From: Richard Castro-Parker
Sent: 06 September 2019 13:35
To: Samantha Lee
Subject: RE: BE/139/18/PL - Innovation Centre Beeding Close

From: Laura Gibbons
Sent: 30 August 2019 11:57
To: Richard Castro-Parker <Richard.Castro-Parker@arun.gov.uk>
Subject: RE: BE/139/18/PL - Innovation Centre Beeding Close

Laura Gibbons, MEng, GMICE
Engineer (Drainage & Coastal)

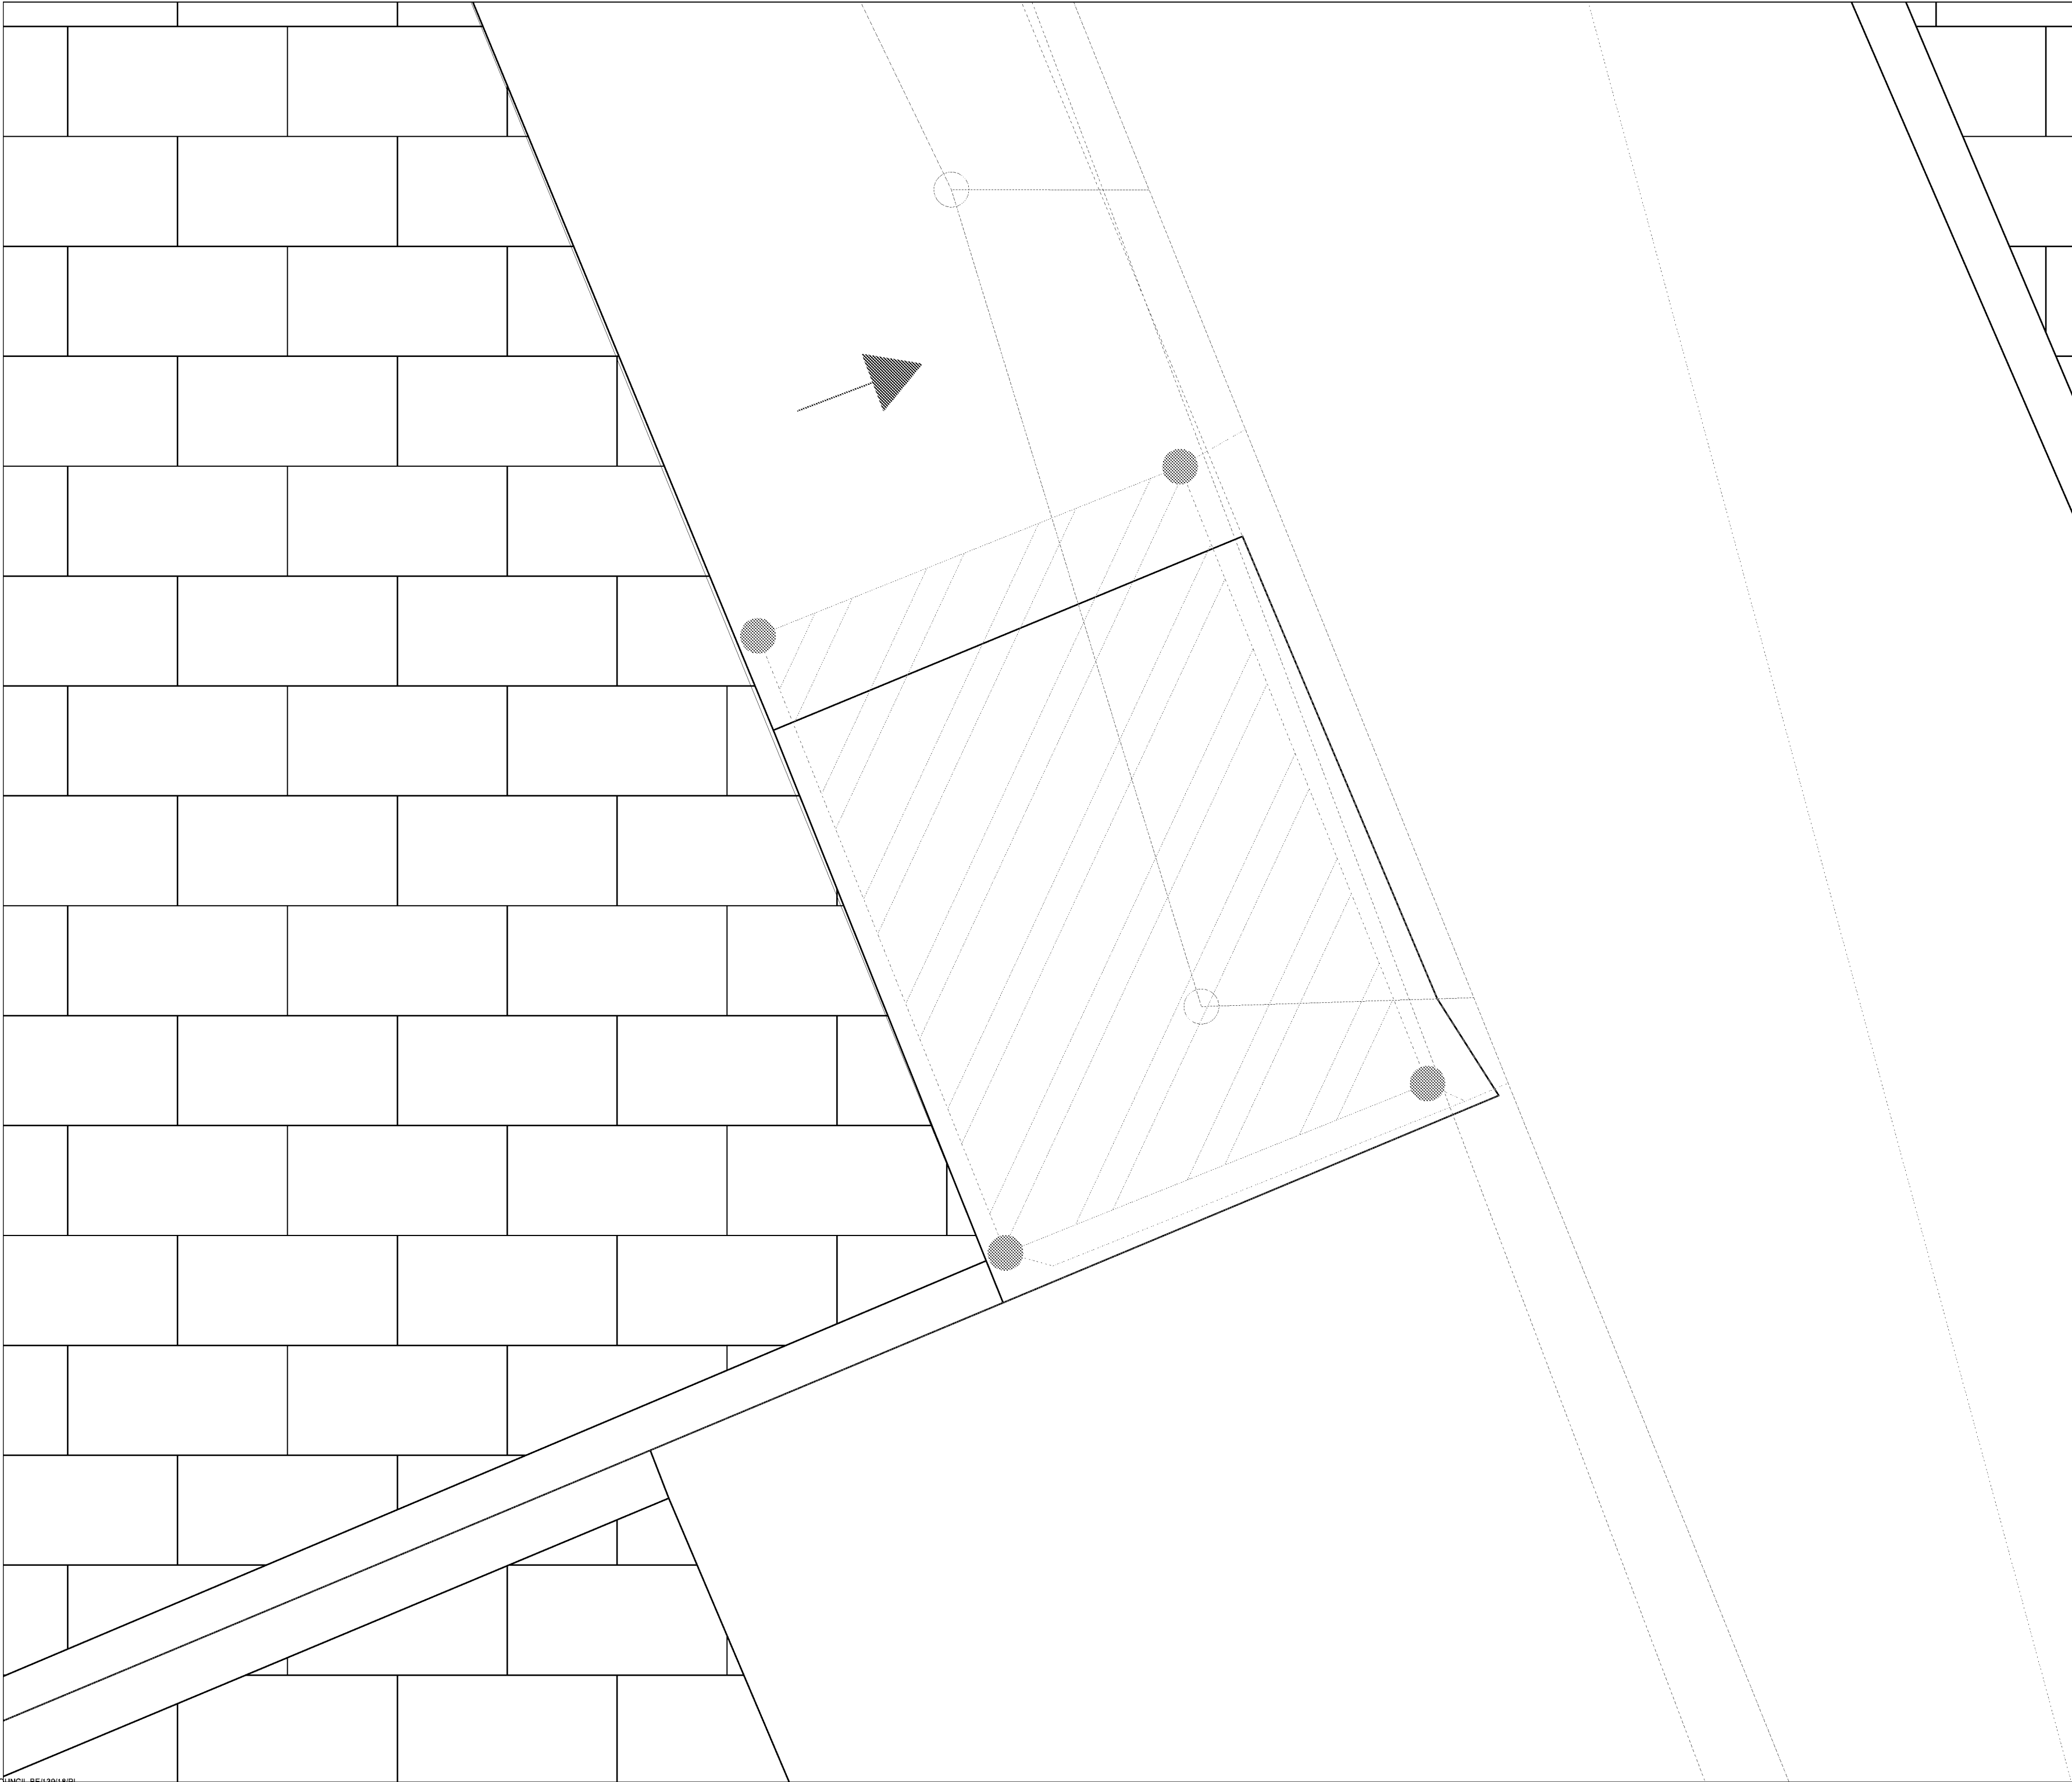
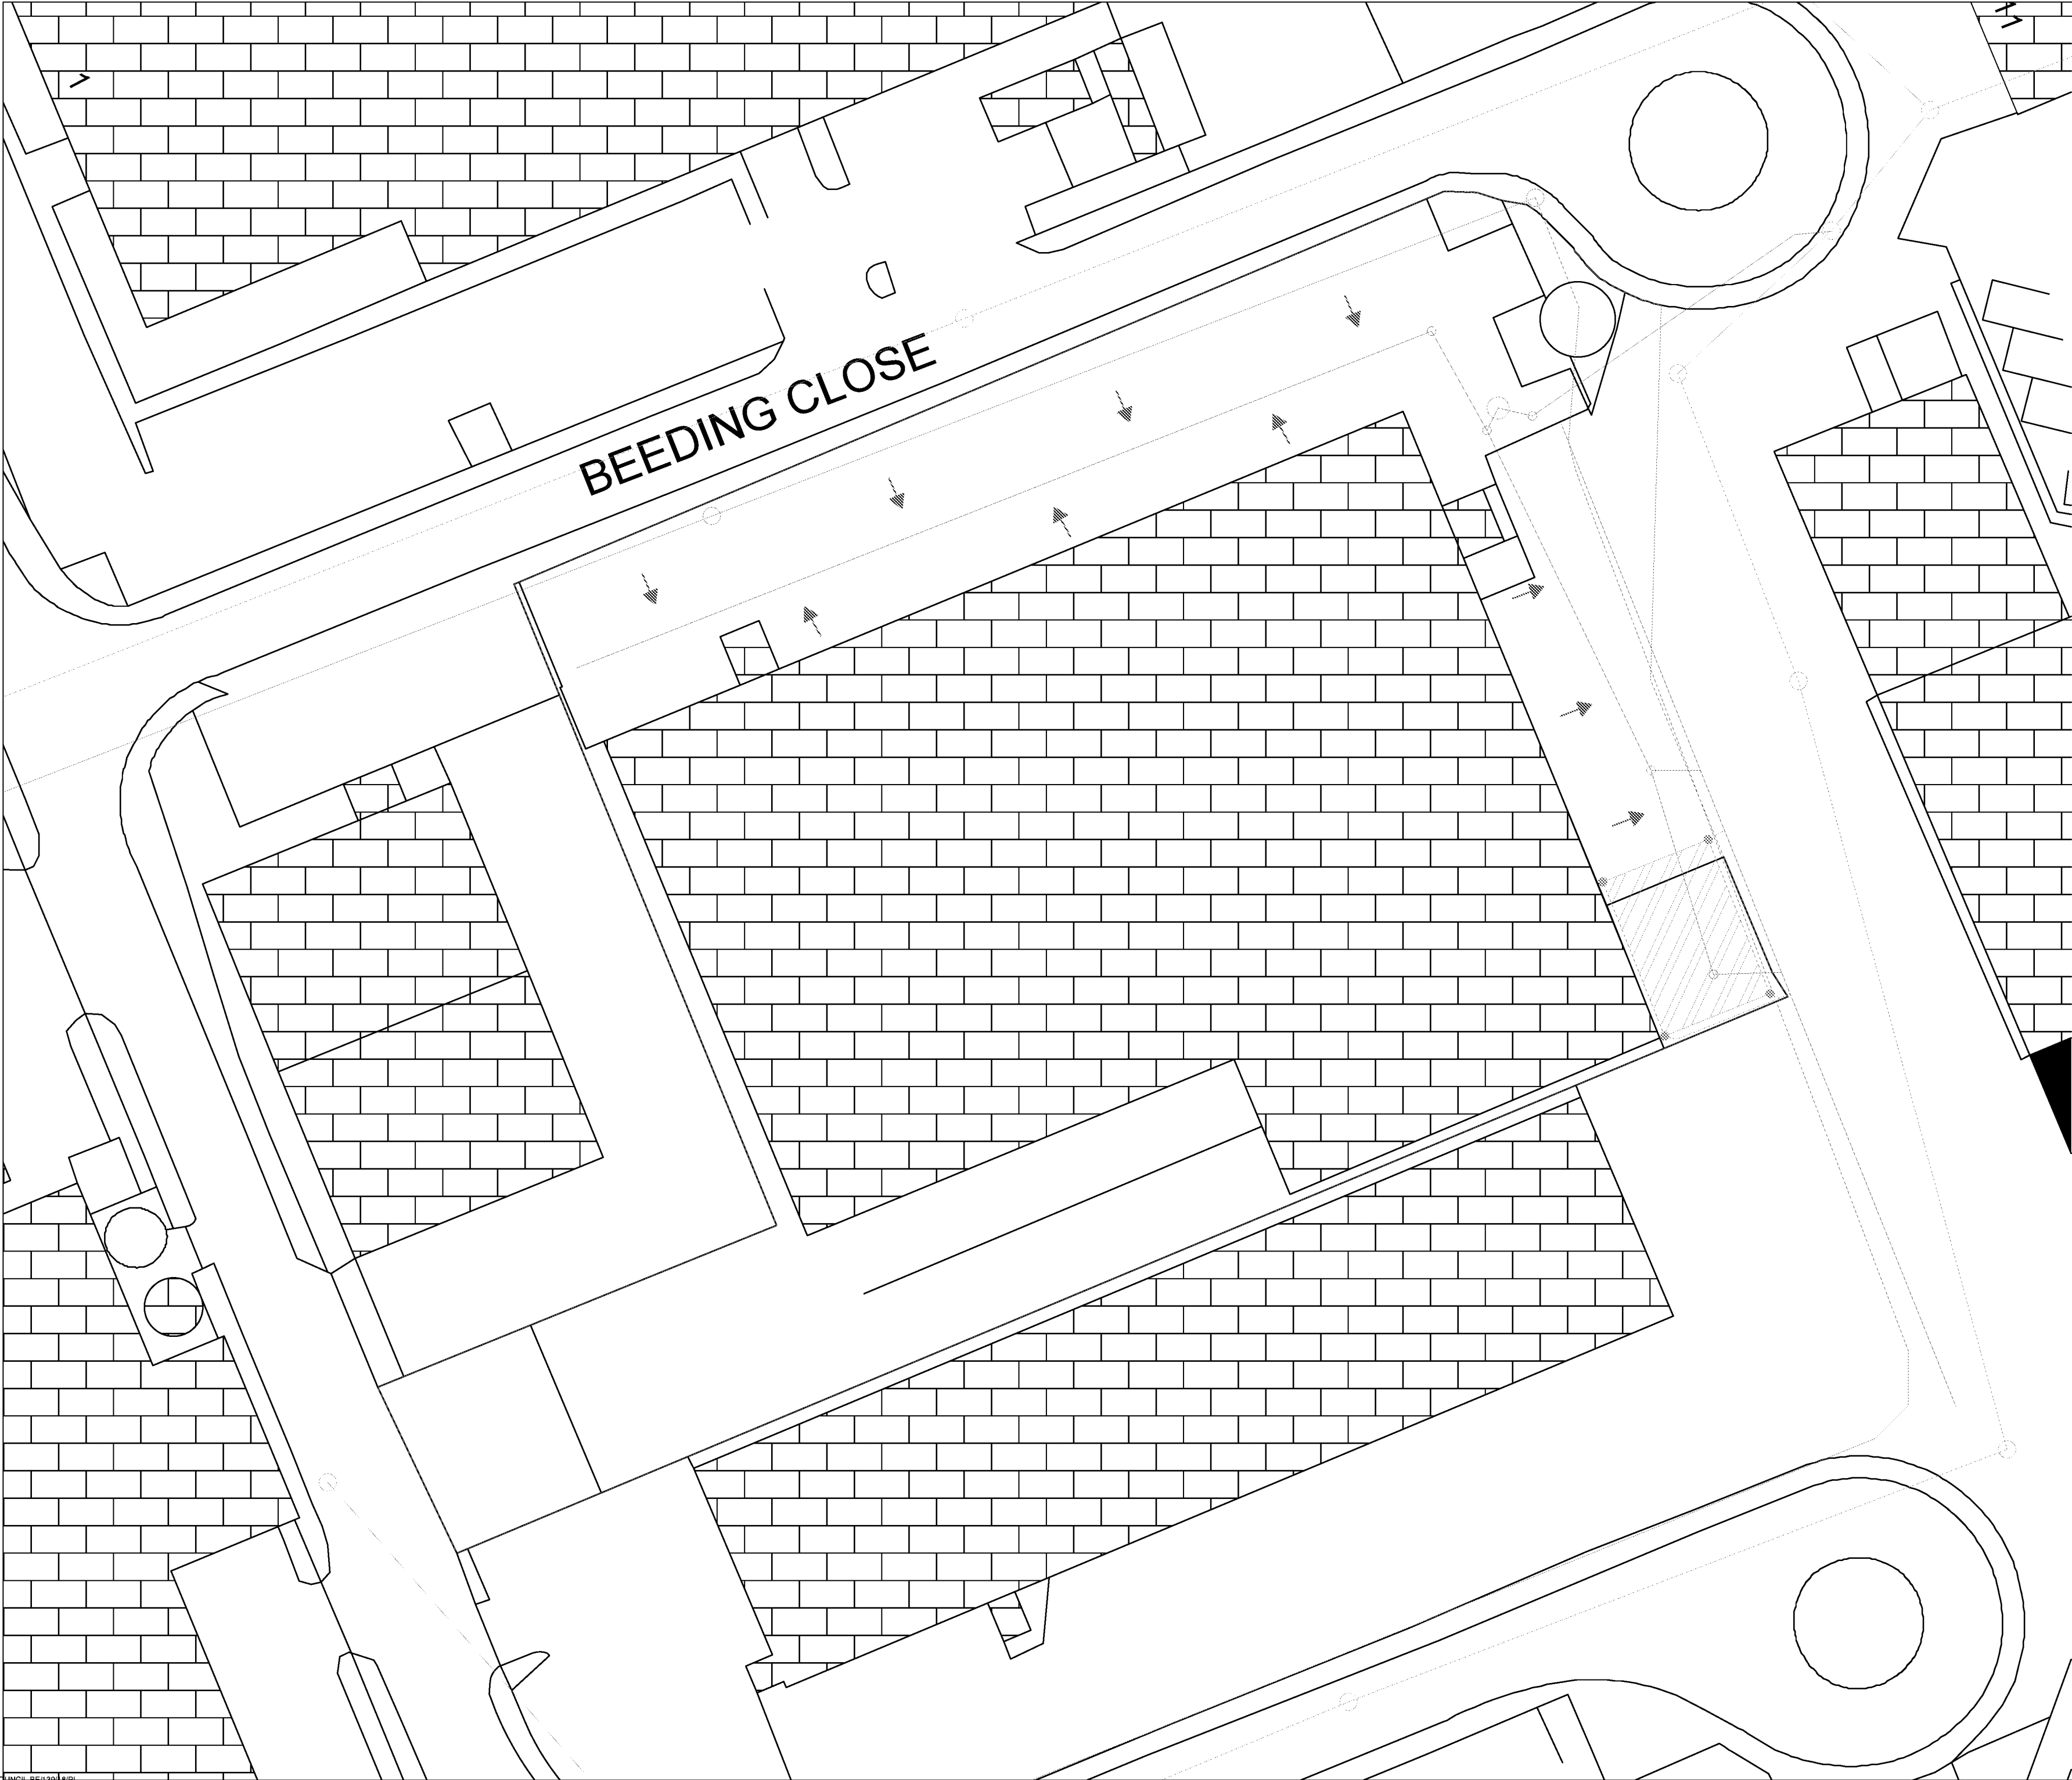
I still am struggling to distinguish between lines. Please can different line types be used, rather than all very similar colours. Please can gullies, manholes, and linear drainage channels be clearly labelled.

Regarding the levels, I also requested some spot levels of the surrounding land, can these be provided. This is fundamental to ensure that the surface water from the development does not go off site.

Please can the applicant submit clearer plans of the proposed surface water drainage arrangement. I.e. different line types used, rather than all very similar colours. Please can gullies, manholes, and linear drainage channels be clearly labelled.

I also require levels to be submitted showing invert and cover levels of the existing drainage network and spot levels of the surrounding land. This is fundamental to ensure that the surface water from the development does not go off site.

The colour of the lines have been changed and it is very different from each other in my screen. Please therefore let me know if Laura is still unable to distinguish them. I've also got confirmation from the client that they already have someone booked in to have the drainage cleaned.

With regard to spot levels, could Laura ascertain whether the Environment Agency LiDAR information would be sufficient information to determine the rough elevation of the surrounding land? Unfortunately, our flood consultant is not qualified to undertake a topographical survey of the surrounding land. We will therefore have to appoint a surveyor separately just to do the full survey for the displacement of 150sq.m of roof water.

Please find attached a PDF of the drainage layout plan for the site. Given the size of the site, all lines on the plans are small. However, if Laura zooms in she will be able to distinguish between the pipes types. This should hopefully address her first concern.

With regards to levels, having reviewed the sewer asset location search requested from Southern Water, both invert and cover levels for all Southern Water manholes are detailed within their response. A copy of the sewer asset location search was included within the appendix of the Surface Water Drainage Strategy – this have been attached to this email for her reference.
